PARKER DANN

Land at the entrance to Waterford Gardens, Climping
Planning application for the erection of 1 No 4 bed dwelling and garage (renewal
of planning permission reference CM/18/11).
Council ref : CM/29/14/PL

PD/01 : SITE LOCATION PLAN

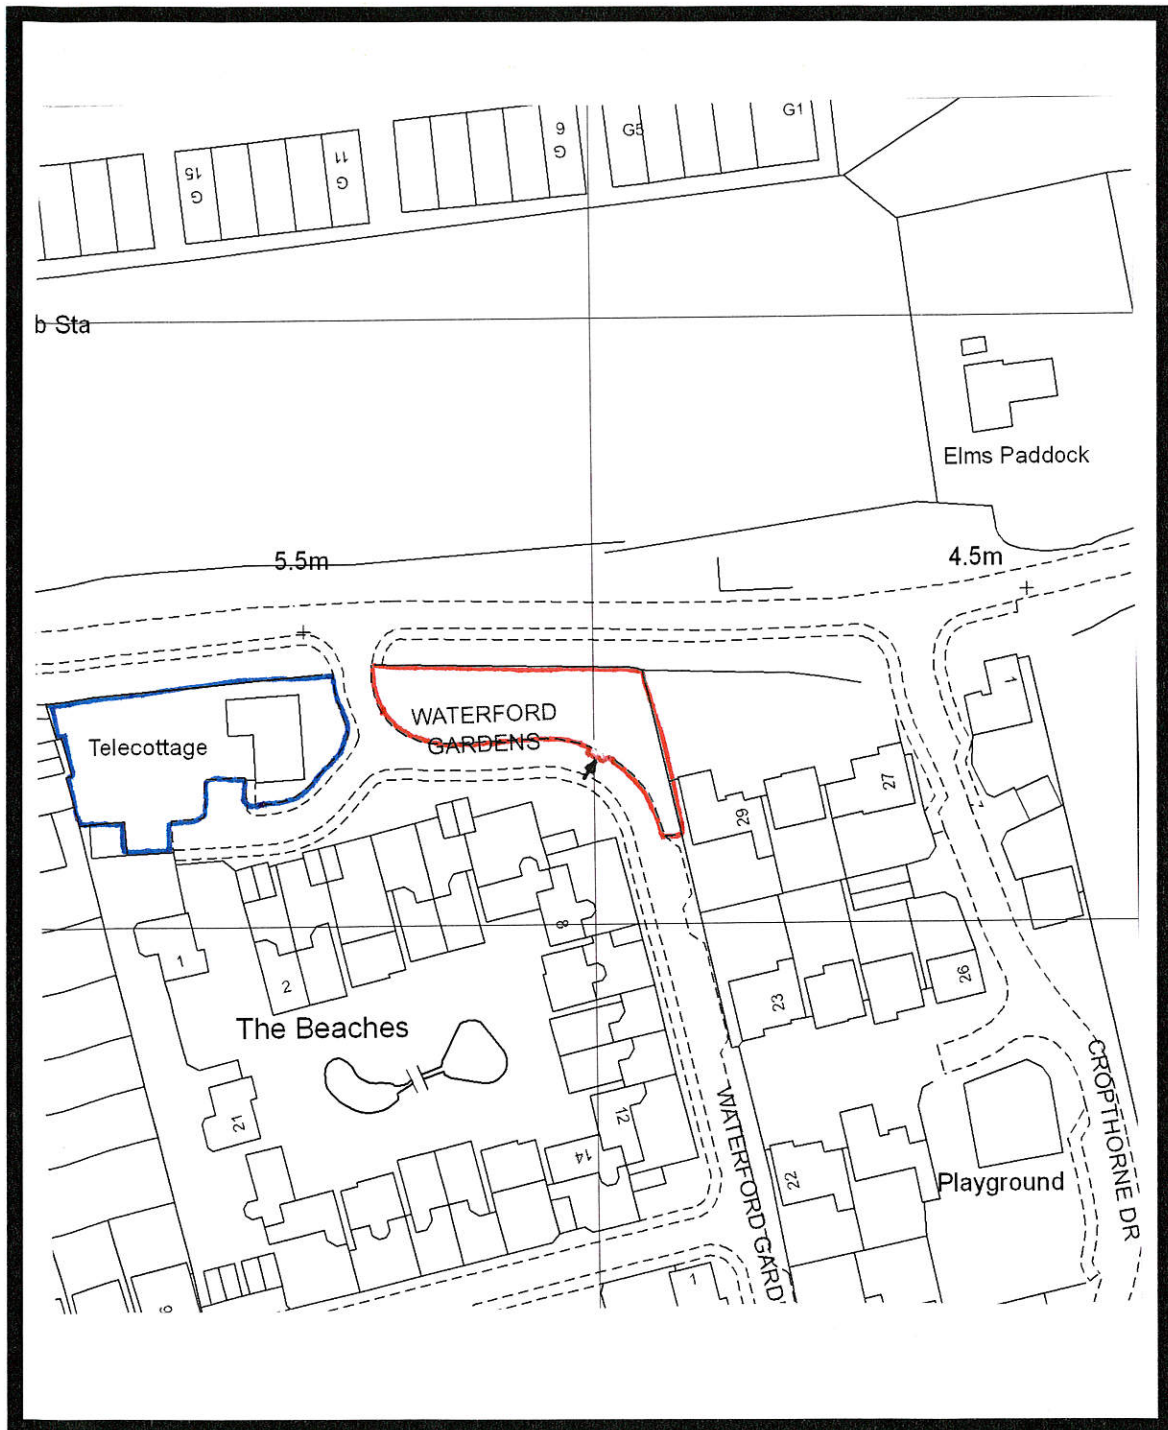
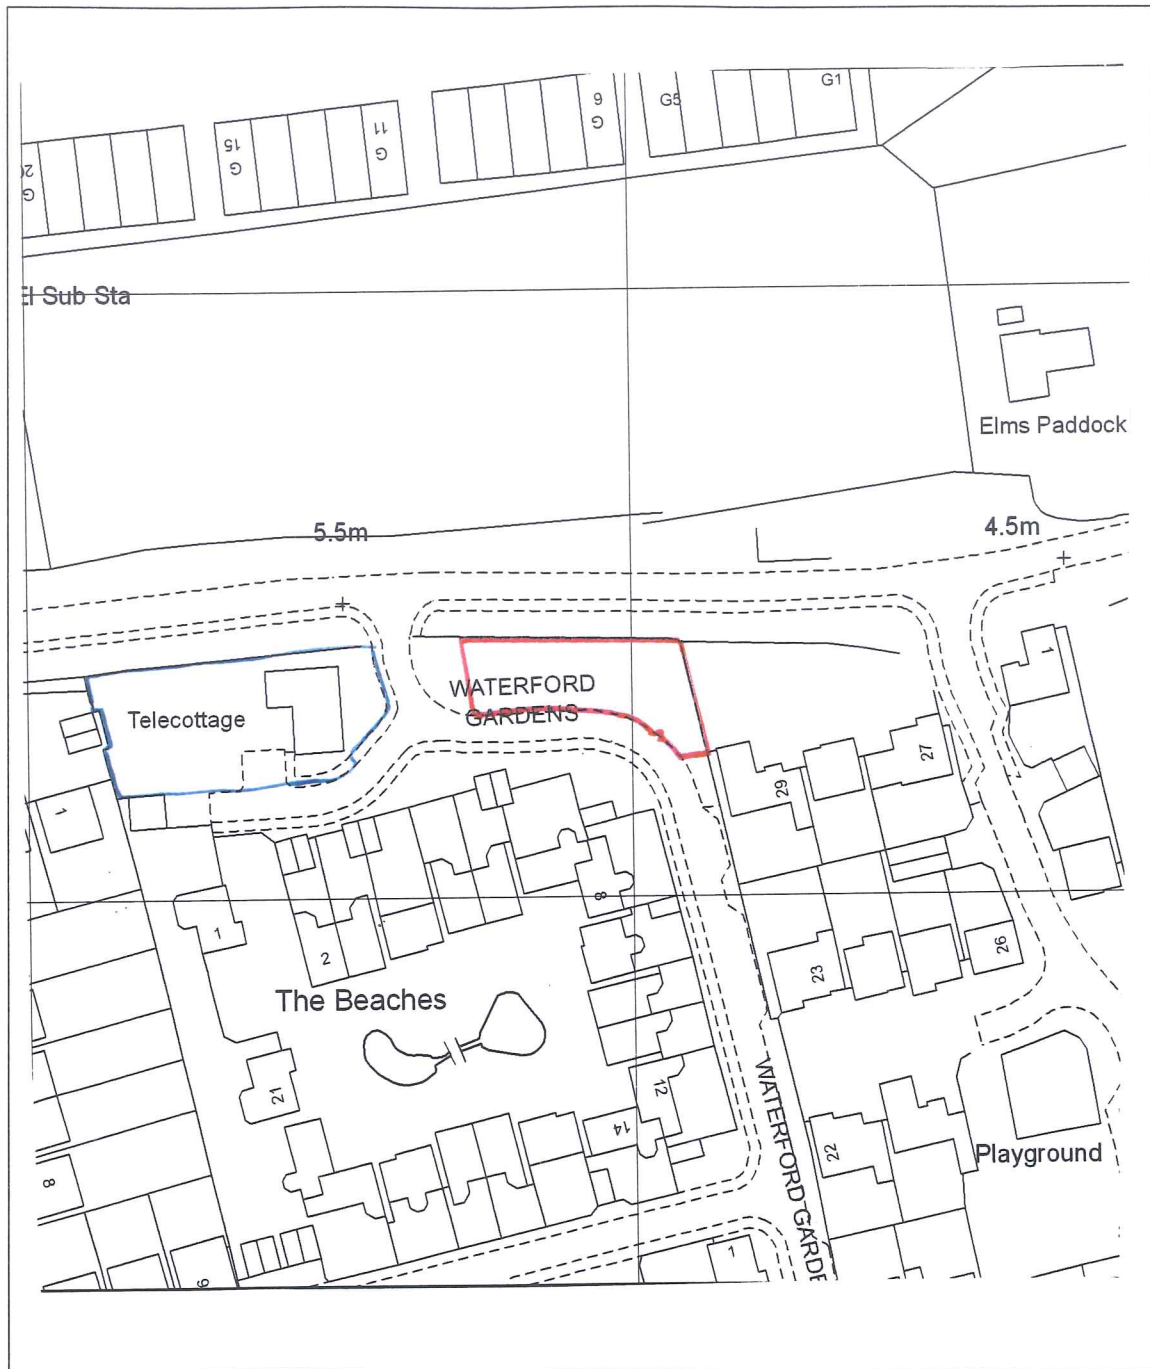
It has been brought to my attention that the Site Location Plan (PD/01) submitted with the above application is incorrect as it does not correctly reflect the extent of the applicant's land ownership.

Please find attached two copies of the correct Plan (PD/01 Rev A) that I would be grateful if you could use in place of the original plan. None of the other drawings submitted with the application need to be altered to reflect this change.
